Permit No: 01-0212	Issue Date: MAR 26 2001	CBL: A002001
Owner Name: McAllister Farms LTD	Contractor Name: Tri-R-Erection	Phone: 781-958-0909
Contractor Address: 18502 Forest Elms Drive Spring	Phone: 2813556137	
Permit Type: Alterations - Commercial		Zone: F-M

BUILDING PERMIT REPORT

DATE: 21 MARCH 2001 ADDRESS: 324 Riverside Street CBL: 317-A-002

REASON FOR PERMIT: To install rack storage for auto glass

1 KEE RACKS (201-1)

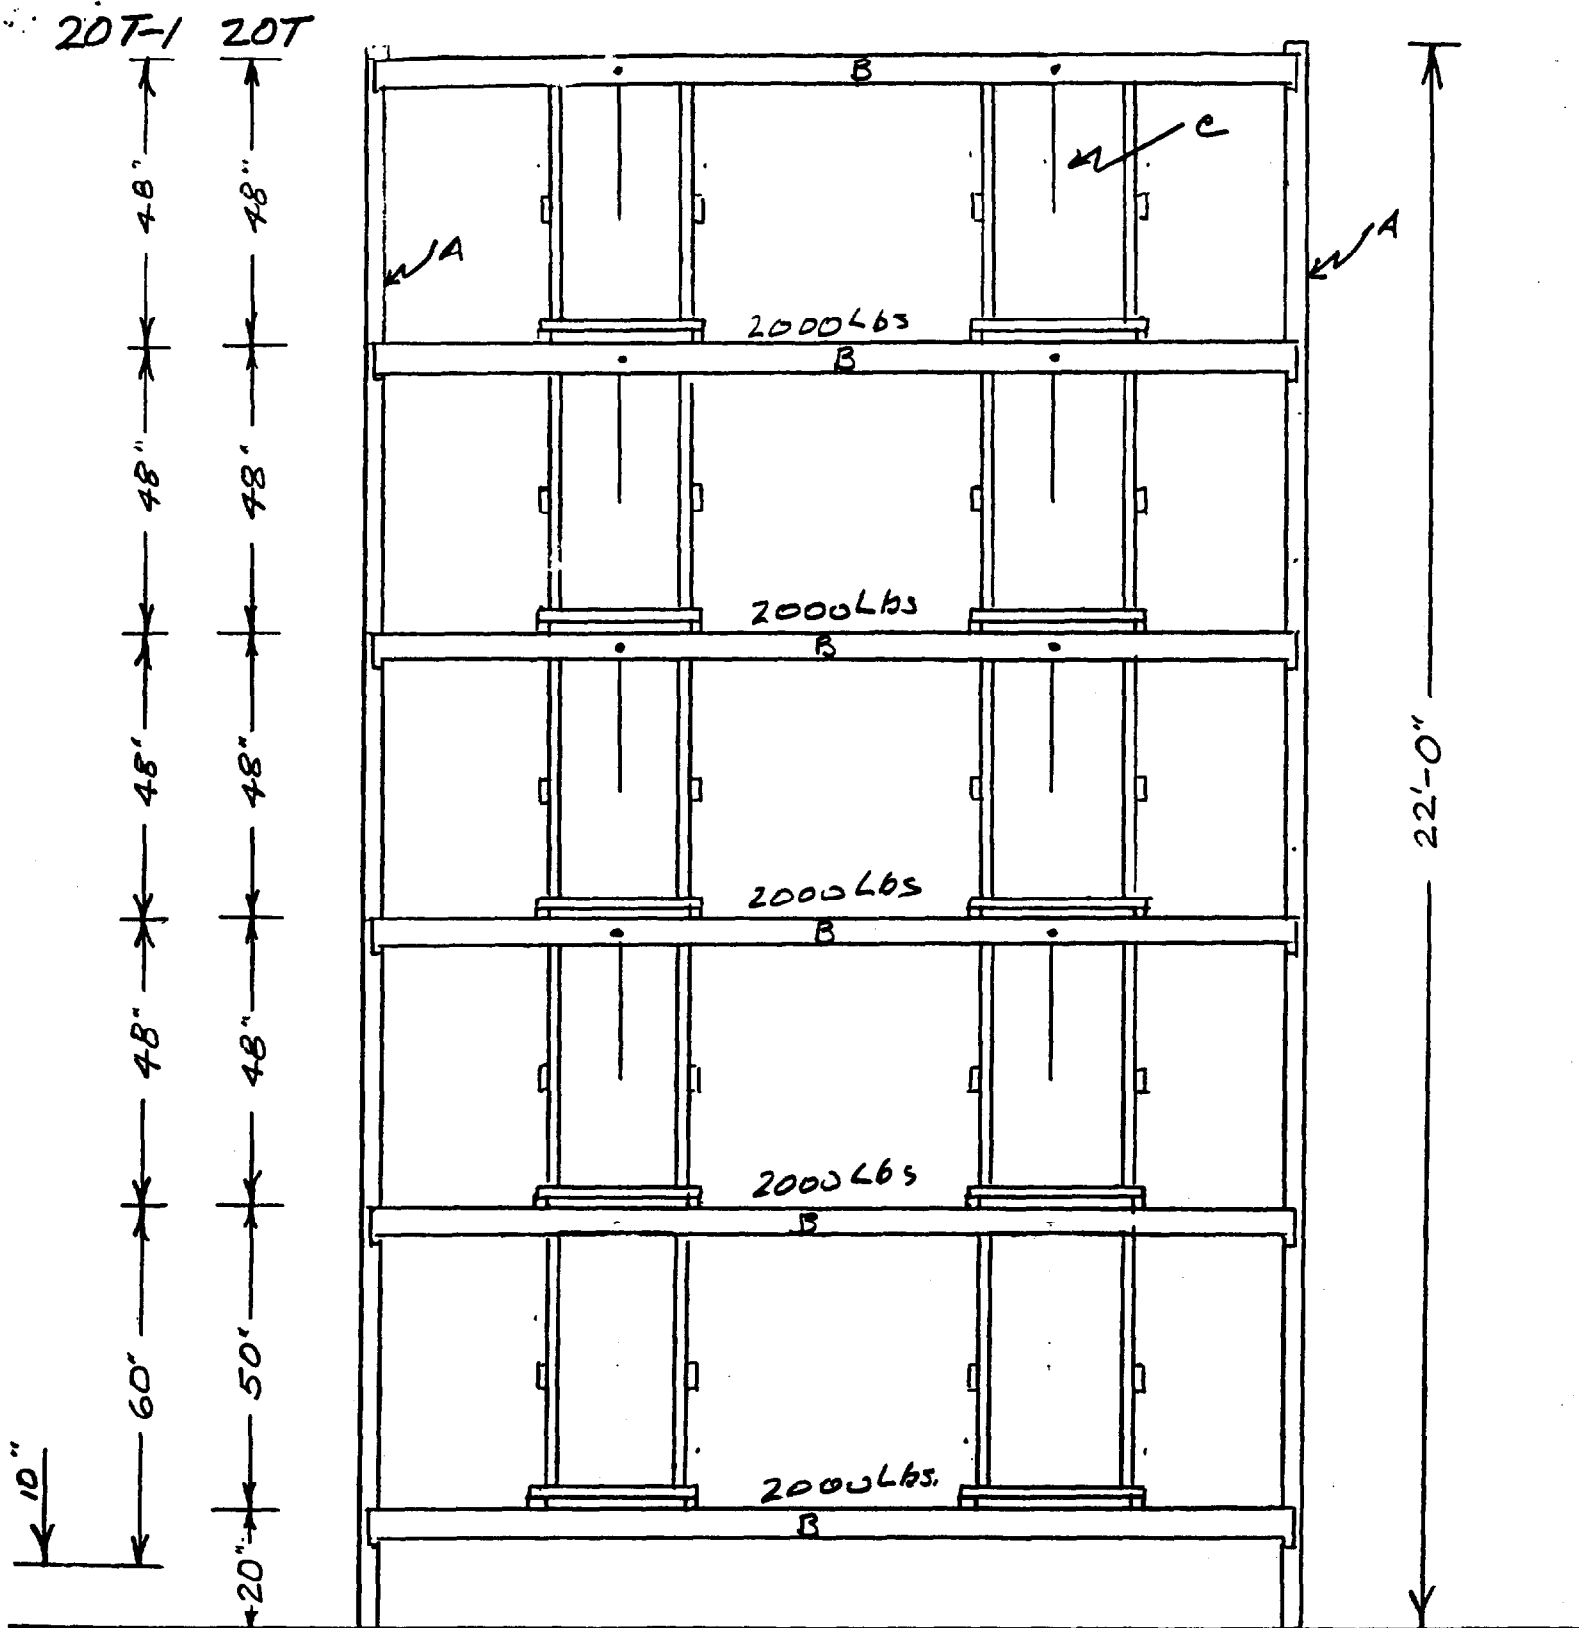
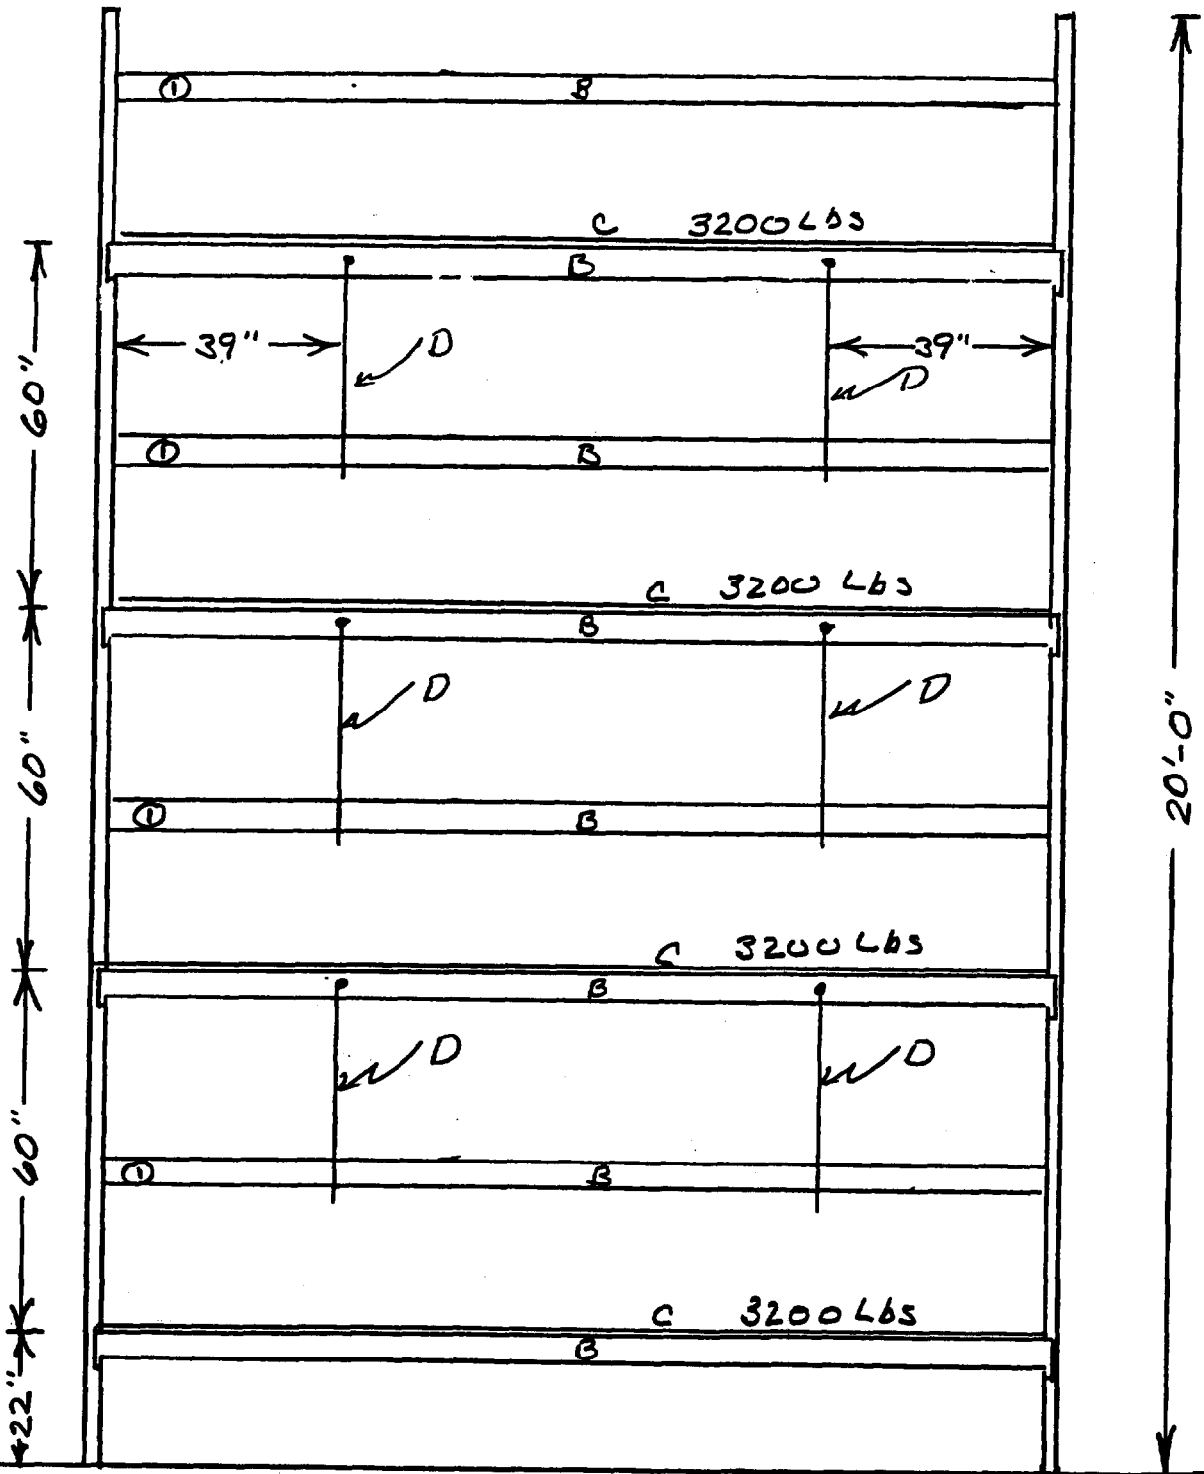
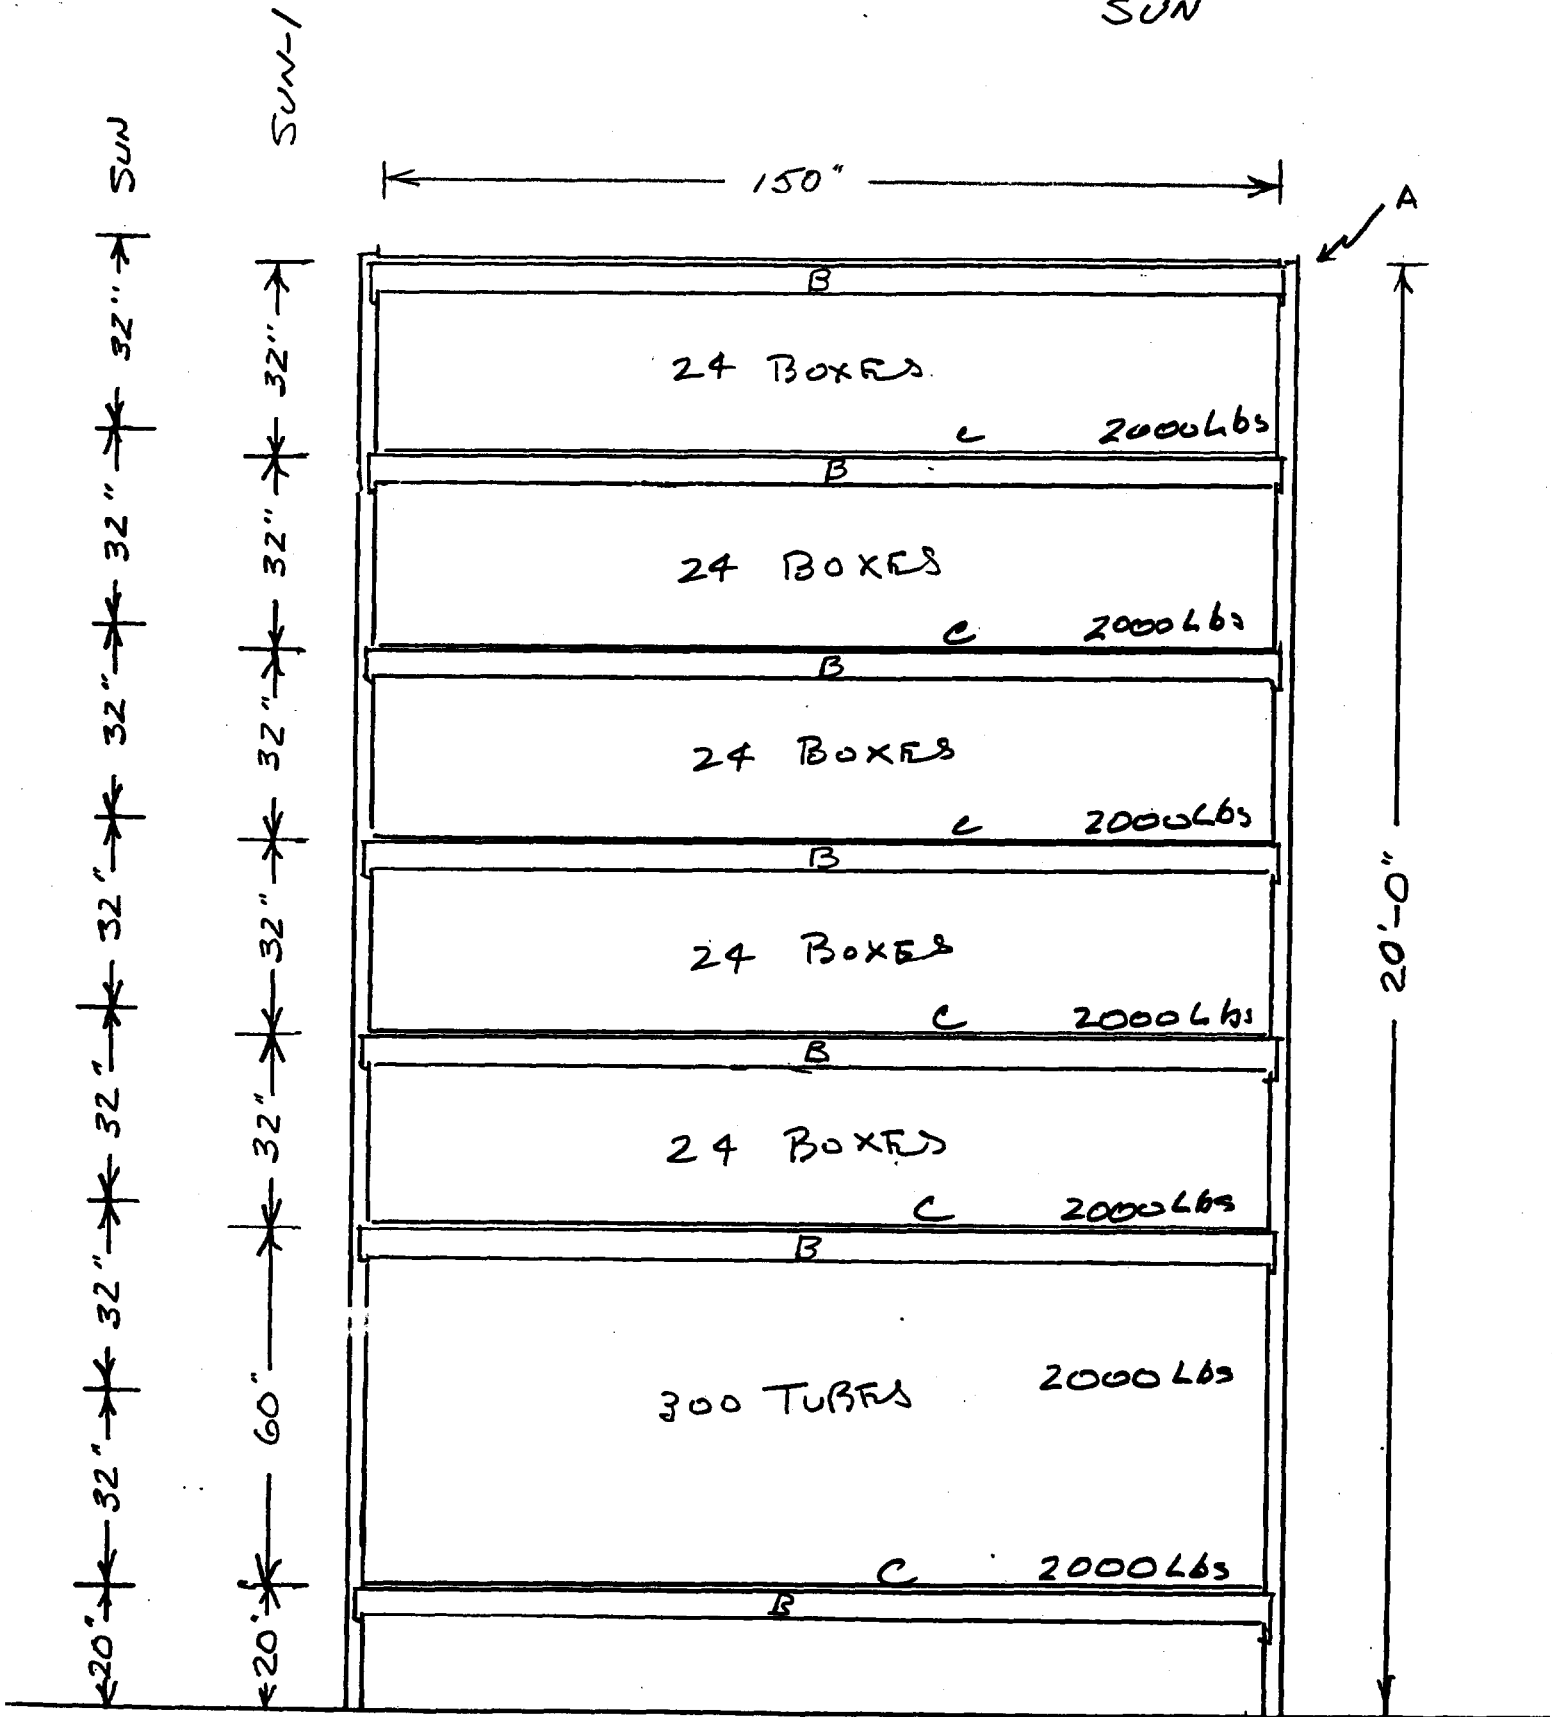
*38. Storage racks shall comply with Section 422.0 of the City's Building Code.

*39. BOSCH METAL BUILDING CODE 1999
Your plans submitted did not show nor bear the seal or signature of a professional engineer on the design of the racks and capable of the racks to carry the loads placed on them. Please submit this in format.
